RE: ENGINEER'S CERTIFICATION FOR MANZANO BAPTIST CHURCH
(L-22/D47) RECEIVED NOVEMBER 16, 1990

PROJECT TITLE: MANZANO BAPTIST CHURCH ZONE ATLAS/DRNG. FILE #: L-22/D47

RE: REVISED DRAINAGE PLAN FOR MANZANO BAPTIST CHURCH
(L-22/D47) REVISION DATED July 30, 1990

RE: DRAINAGE PLAN FOR MANZANO BAPTIST CHURCH
(L-22/D47) RECEIVED JULY 22, 1988

#### GRADING & DRAINAGE PLAN

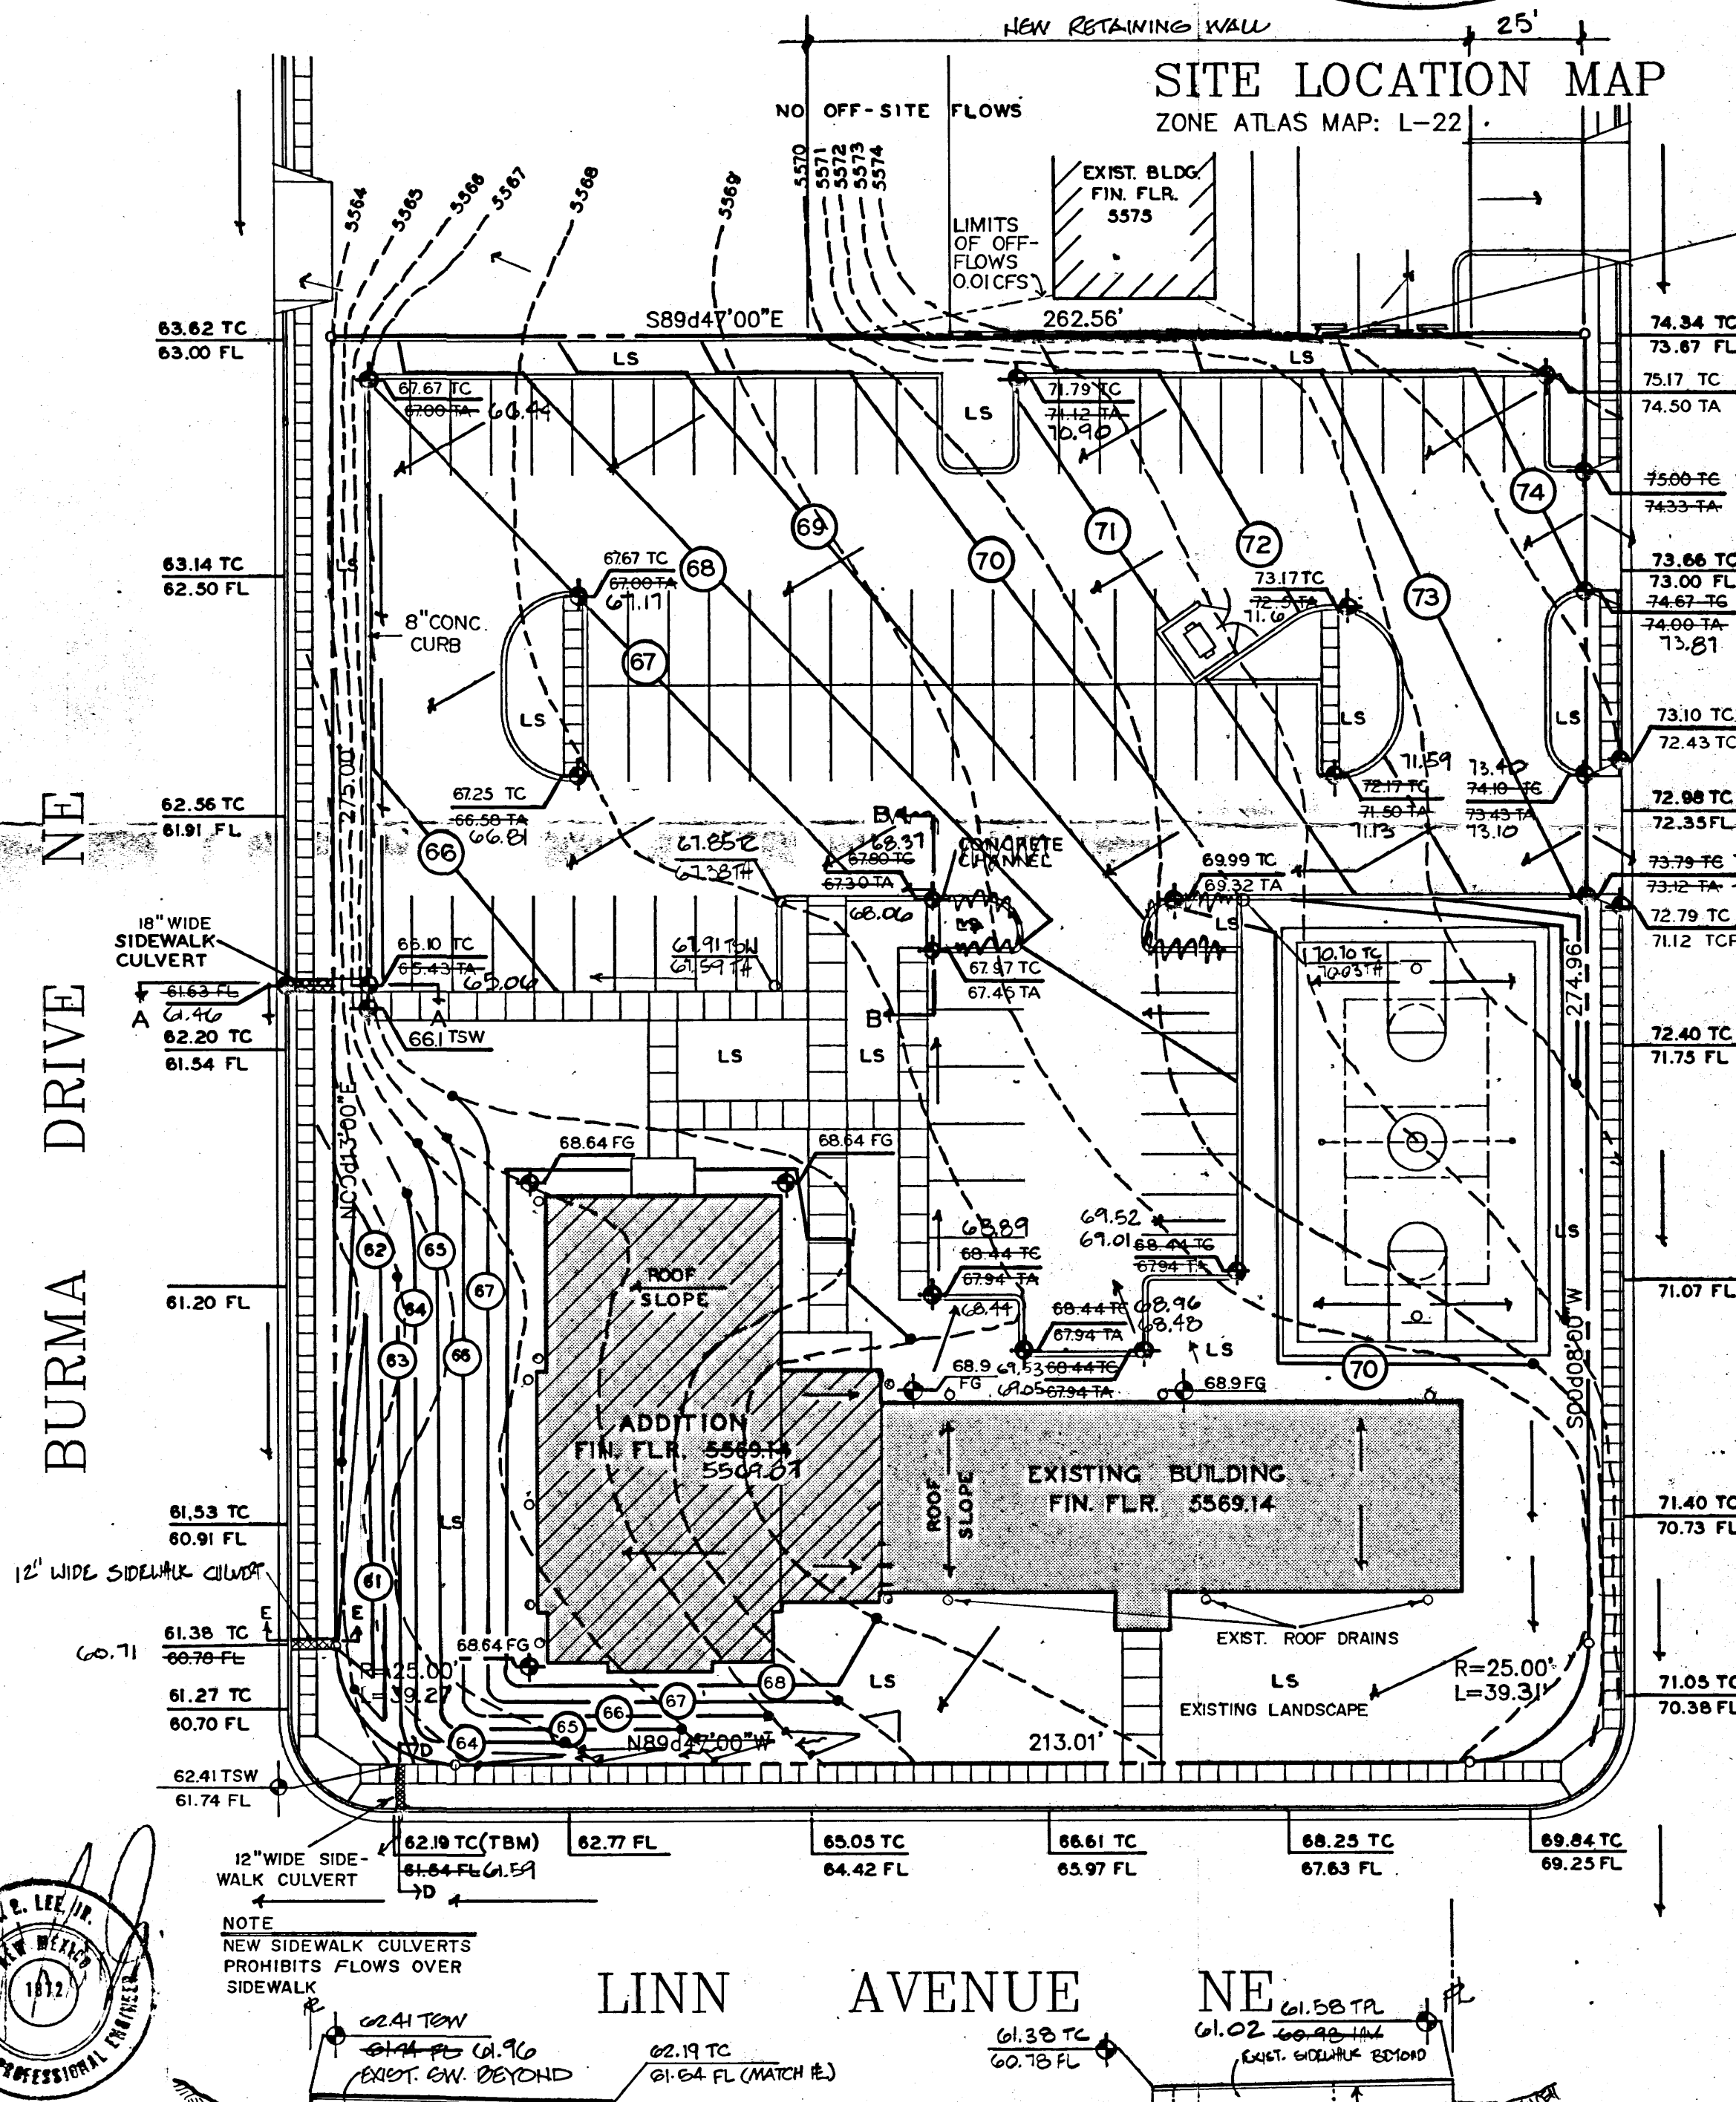
Please be advised that the Certificate of Occupancy will not be released until we receive concurrence from construction for the S.O. #19 work. The DPM checklist indicates that with your certification submittal, you must provide copies of construction approval from the appropriate government agencies for construction within their right-of-way and or easements.

Alo, roof runoff must be routed towards the sidewalk culverts and not over the public sidewalk.

1. How do you propose to handle the 0.01 cfs of offsite flows? You cannot pond it on the proposed landscape area.
2. Roof runoff from the west side of the proposed addition has not been addressed yet. You must direct this runoff towards the asphalt area and not over the public sidewalk.
3. Construction notes along with the sign-off block from the S.O. #19 format must be included within the plan drawing.
4. Two copies will be required with the resubmittal.

1. existing contours indicate you may have off-site flows entering the site at the northwest corner;
2. sidewalk culvert calculations will, will the proposed culvert release the developed 8.41 cfs?
3. roof run must be routed towards the asphalt area. How do you propose to accomplish these?
4. approved filed copy of replat submitted for our files;
5. engineer's stamp must also be dated;
6. water must be directed into the sidewalk culvert. Is the sidewalk going to be raised enough so as to keep the runoff from being directed elsewhere besides the sidewalk culvert?

This resubmittal, with the addition of a sidewalk culvert at the
southwest corner of the site, is necessary because the contractor
did not grade the west portion of the site per the approved
drainage plan.

The proposed contours shown on the uphill slope reflect the as-
built conditions. The new swale shown at the bottom of the slope
will direct runoff to the new sidewalk culvert as shown hereon.
